# Technical Memorandum

## Re: 1330 Carling Avenue and 815 Archibald Street TIA – Transportation Comment Response

The City of Ottawa provided comments on the TIA Step 4 Report for the development application for the proposed residential development at 1330 Carling Avenue and 815 Archibald Street. These comments were received on July 10, 2020. The following summarizes the comments and the response to the comments.

GROUND FLOOR PLAN

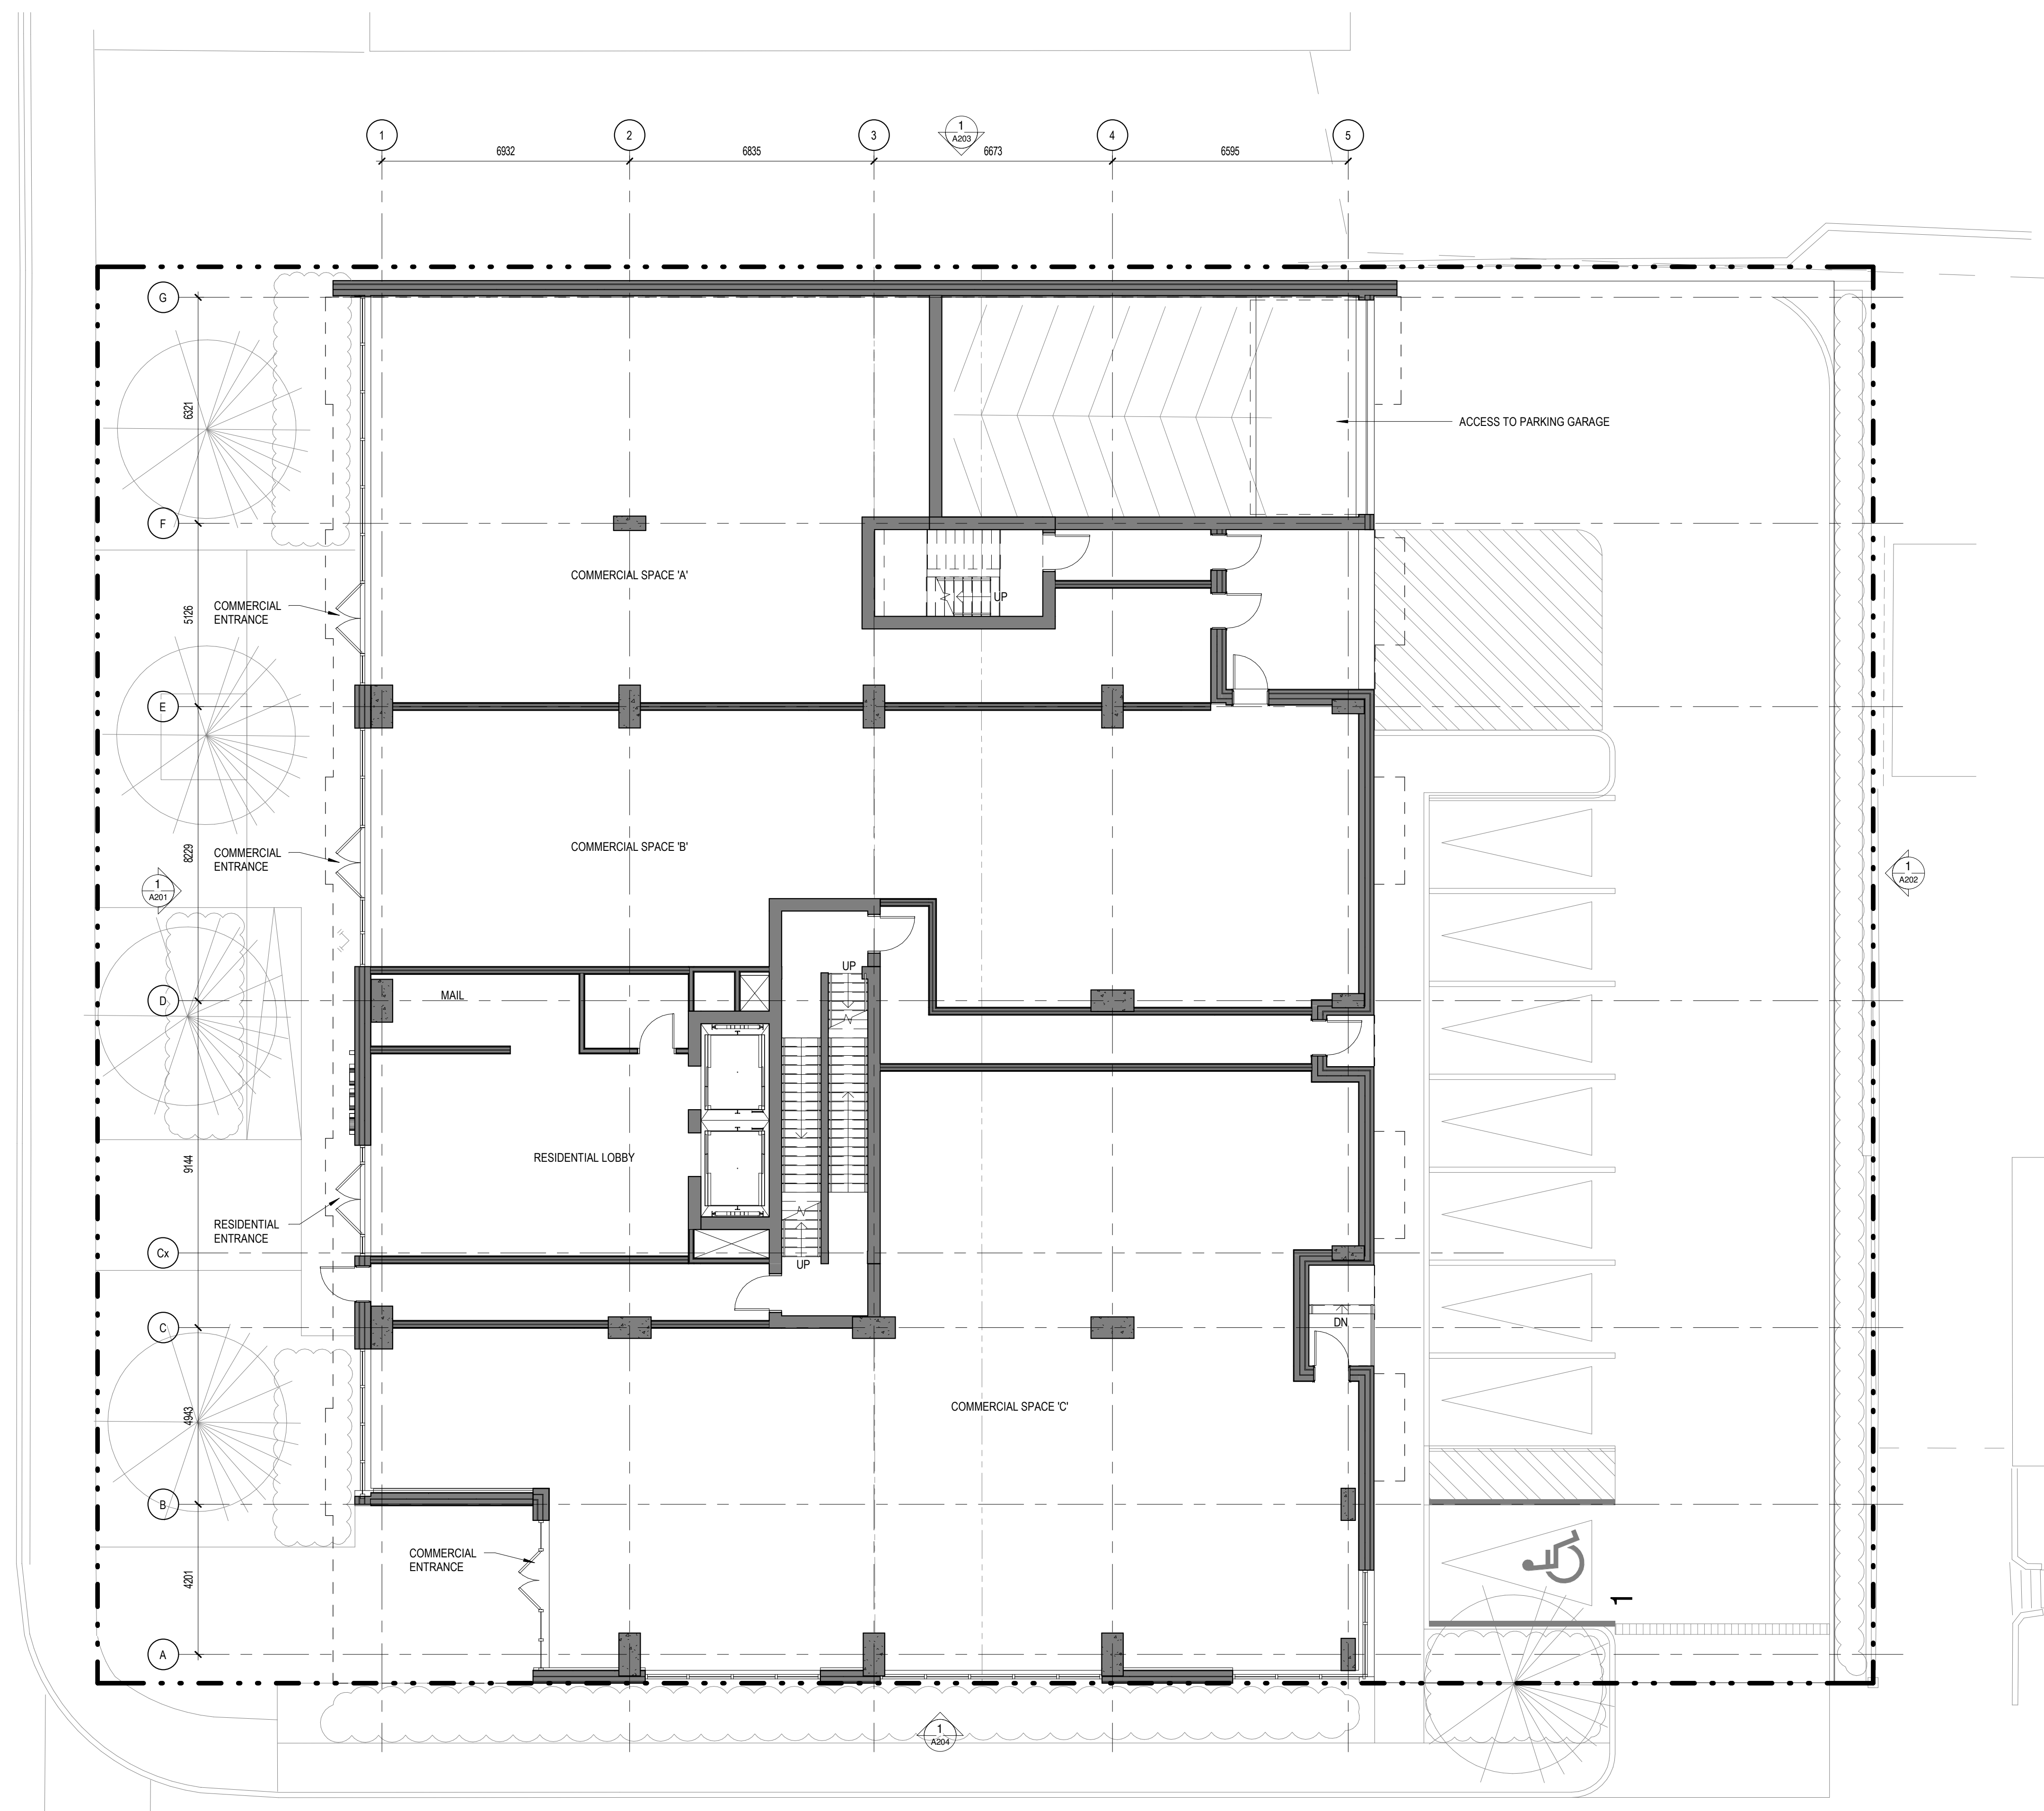
<b>10</b>	Note that a minimum sidewalk width of 1.8m is required per Section 3.3.2 of the City of Ottawa Accessibility Design Standards.	<i>The site plan has been revised to include the minimum sidewalk widths.</i>
<b>11</b>	It is not recommended that any vertical circulation elements (ramps or stairs) that are required for the accessibility of building entrances be located within Carling Avenue’s protected right-of-way, as is shown in the site plan. These ramps and stairs may have to be removed once Carling Avenue is widened to its full protected width.	<i>Noted. Further details may be available in the site plan package and comment responses.</i>
<b>12</b>	Suggest the approximately 7m-long section of planting bed adjacent to the corner site triangle (west corner of the building) between the retail entrance and the Archibald Street sidewalk is removed and replaced with unit pavers.	<i>Noted. Further details may be available in the site plan package and comment responses.</i>
